2022/0217

Upward extension of roof height to create two and a half storey dwellinghouse and the installation of roof lights

21 Chapel Lane, Carlton, Barnsley, S71 3LE

Drawing Title
PROPOSED ELEVATIONS

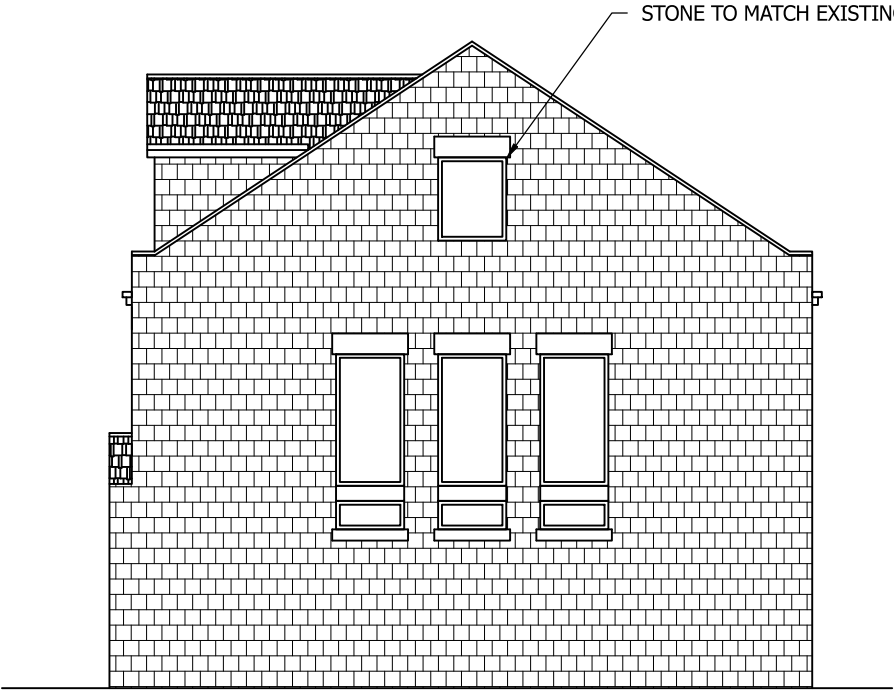
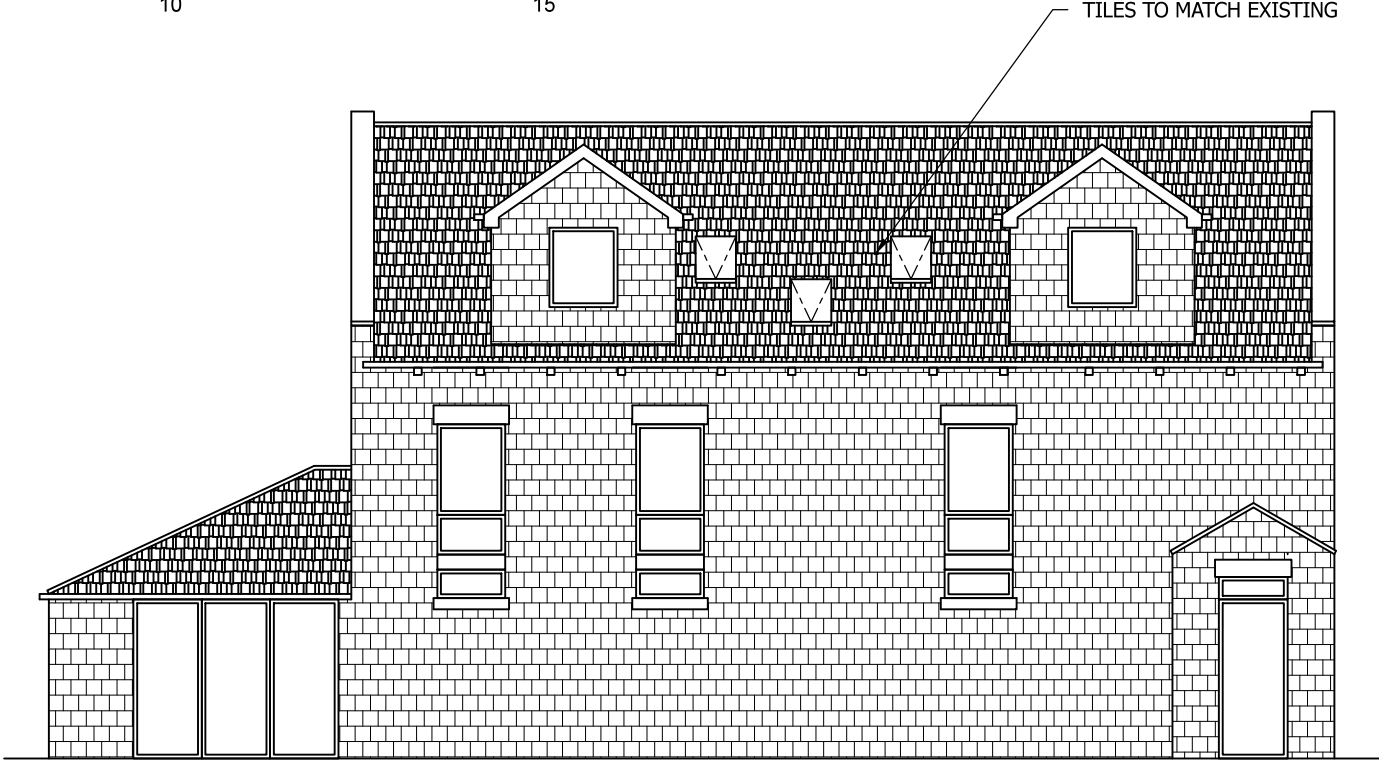
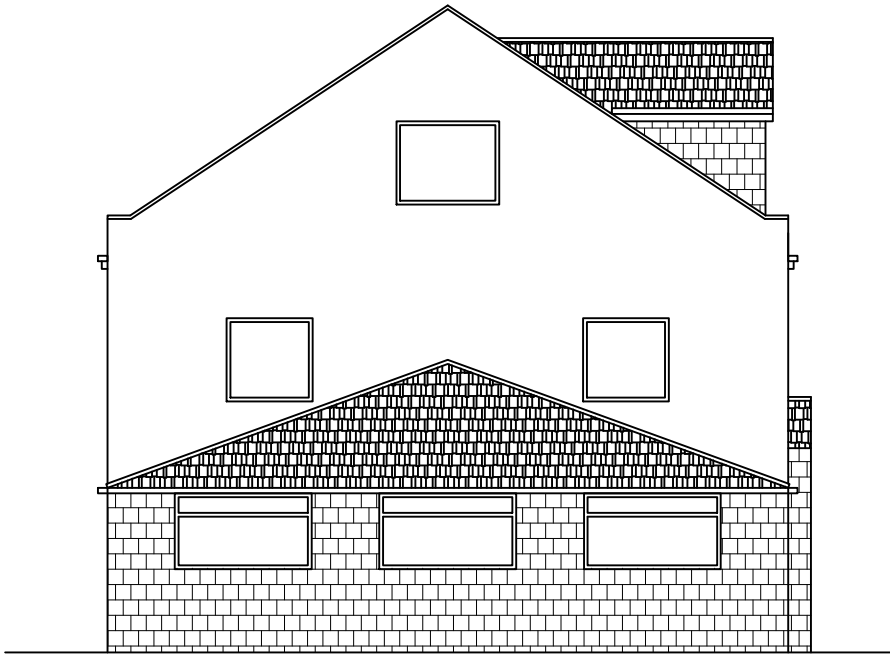
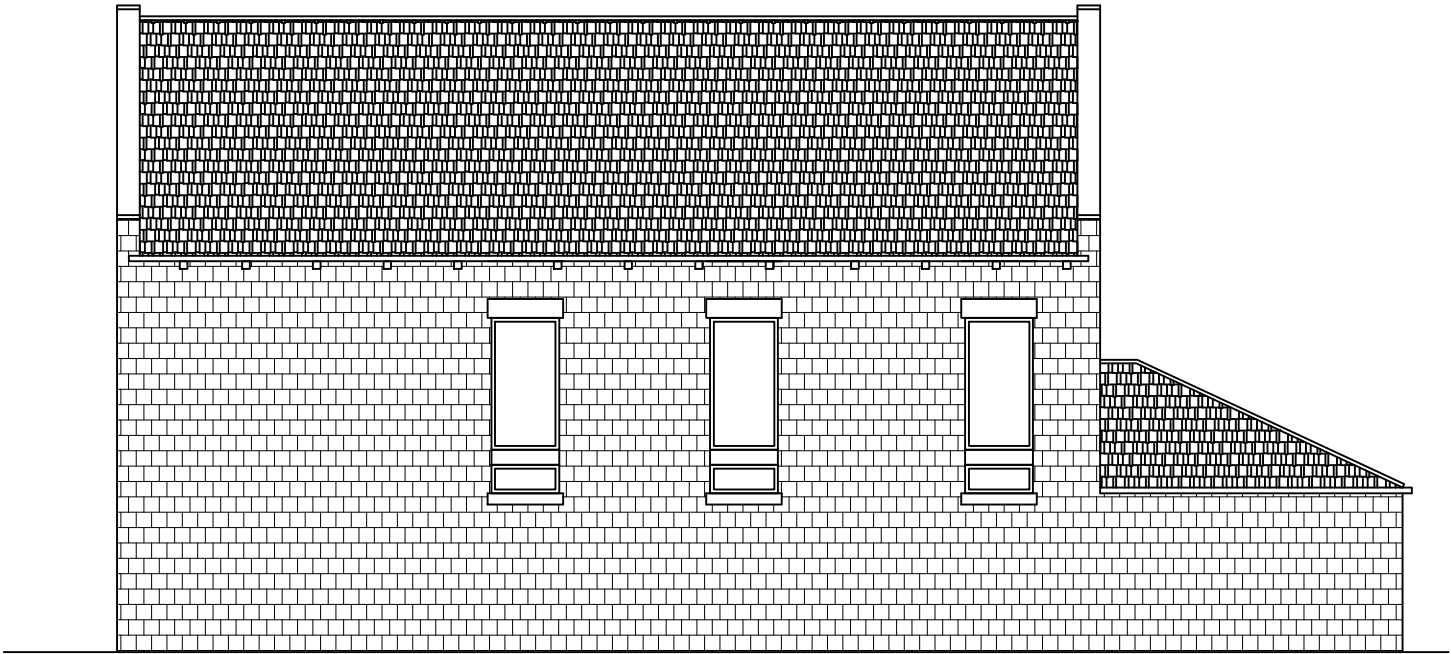
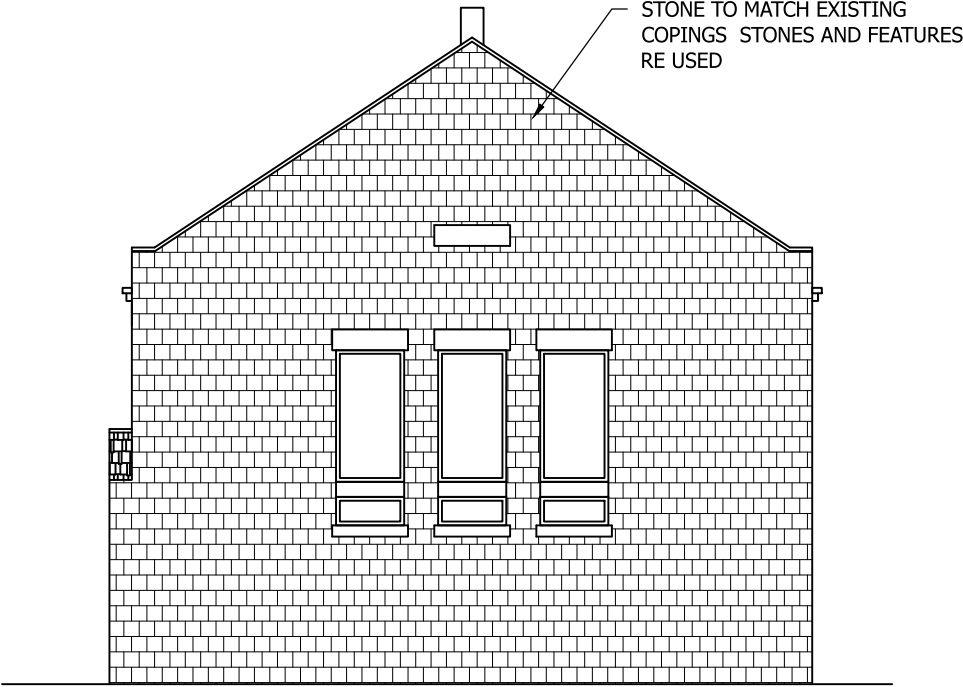
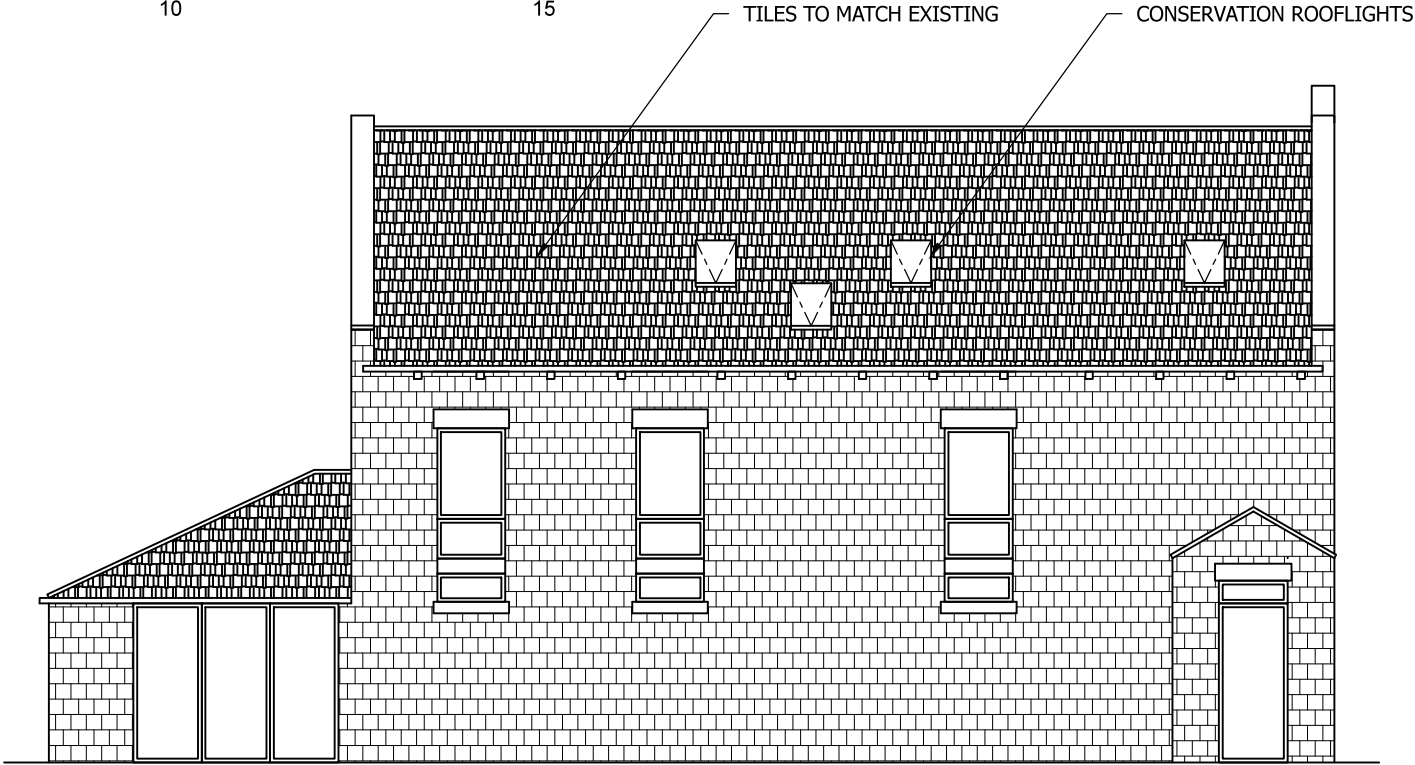
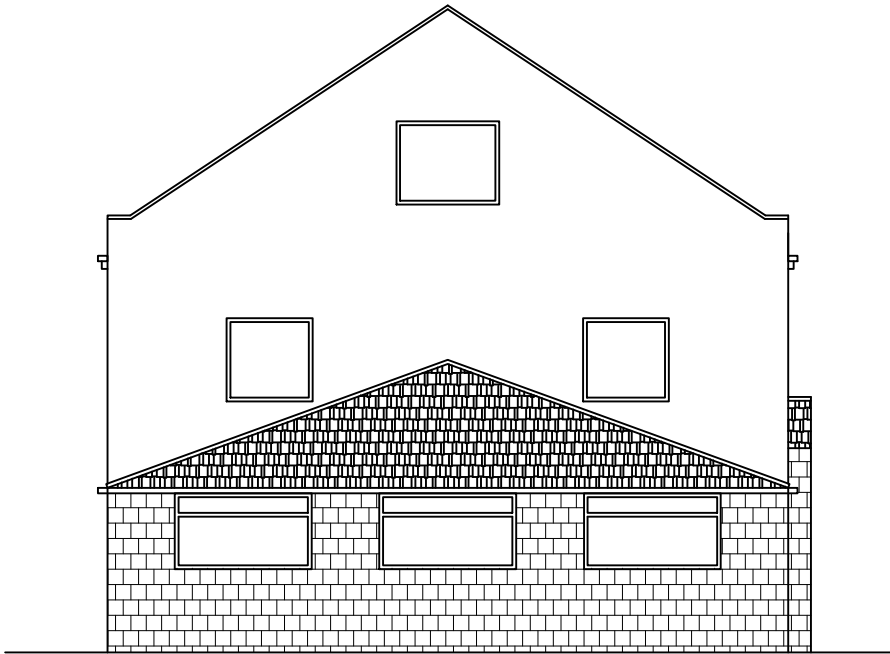
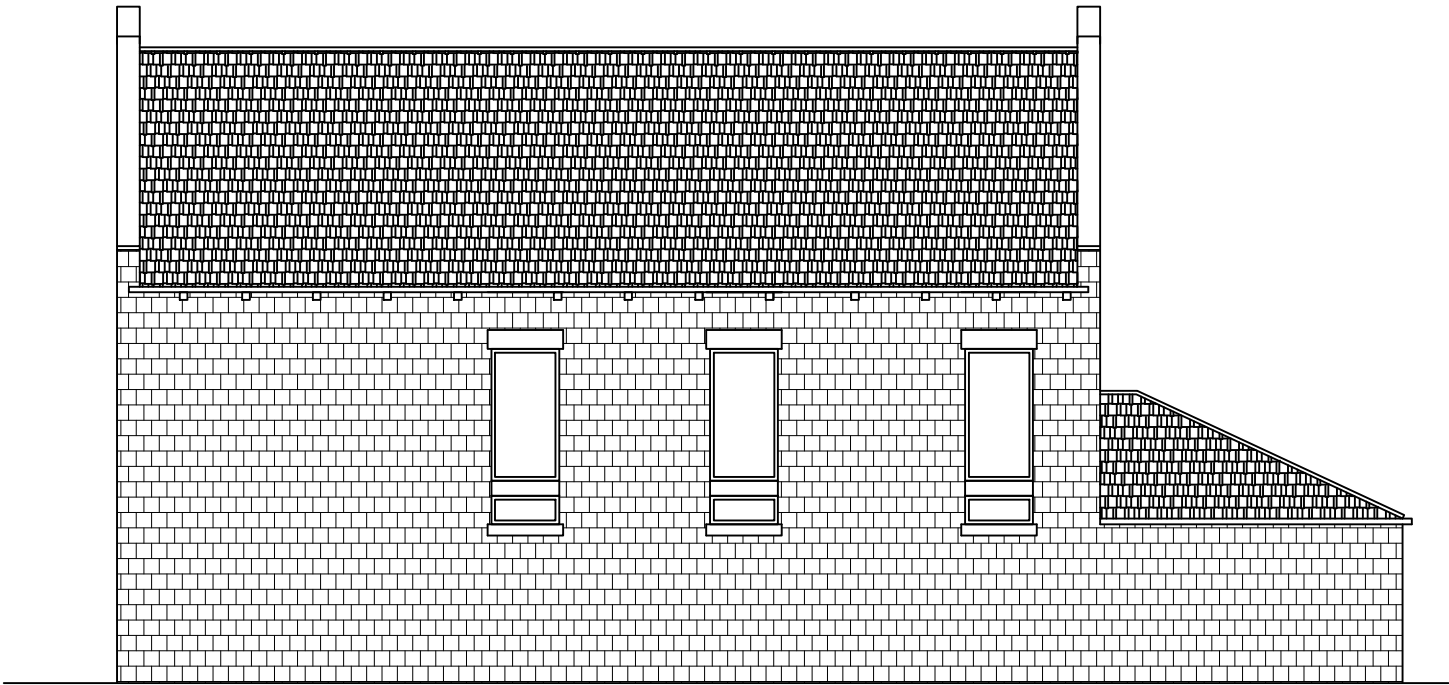
The plans have been amended during the determination of this application. The original plans included 2no pitched roof dormer windows on the northern side elevation, however this, in addition to the increase in height was considered unacceptable.

As mentioned previously, the plans have been amended during the determination of this application. The original plans included 2no vertically proportioned, pitched roof dormer windows to the northern side elevation. It was considered that this form of development on a former Wesleyan Chapel was not appropriate and detracted from the historic appearance of the building.

It is proposed to increase the height of the building by increasing the eaves height by 0.8m and increasing the eaves to ridge height by 0.4m resulting in an overall increase of 1.2m. As mentioned previously, there is no uniform house style within Chapel Lane, with a mix of single and two storey properties and therefore differing ridge heights. Whilst it is proposed to increase the ridge height of the dwelling, it would not be out of character with the area given that the row of properties to the south have a higher ridge height than the existing building; a street scene has been submitted which clearly shows that the dwelling as extended would not be higher than the row of dwellings to the south, and whilst the dwellings to the north have not been included on the street scene this pair of dwellings are set further away from the front boundary which would distort the difference in heights, appearing as the properties are of a similar height. The increase in eaves and ridge heights ensure that the building remains balanced and of similar proportions to the original building.

It is clear, local, and regional Wesleyan chapels, are often two-storey with first floor galleries and a scale akin to a full two stories. The removal of the dormer windows and the gable window, along with the retention of the 'Wesleyan' inscription and the nine-sided cross base on the roof, that the character of the building is largely retained, and the conservation officer raises no objection to the amended scheme subject to conditions.

The alterations are proposed to be made in stone to match the existing, with the elements outlined above indicated on plan to be retained, long with the inclusion of conservation style roof lights, nevertheless conditions will be included to ensure the protection of important detailing. It is therefore considered that on balance, the proposal is acceptable in terms of visual amenity and in compliance with Local Plan Policies HE3: Developments affecting Historic Buildings and D1: High Quality Design and Place Making.
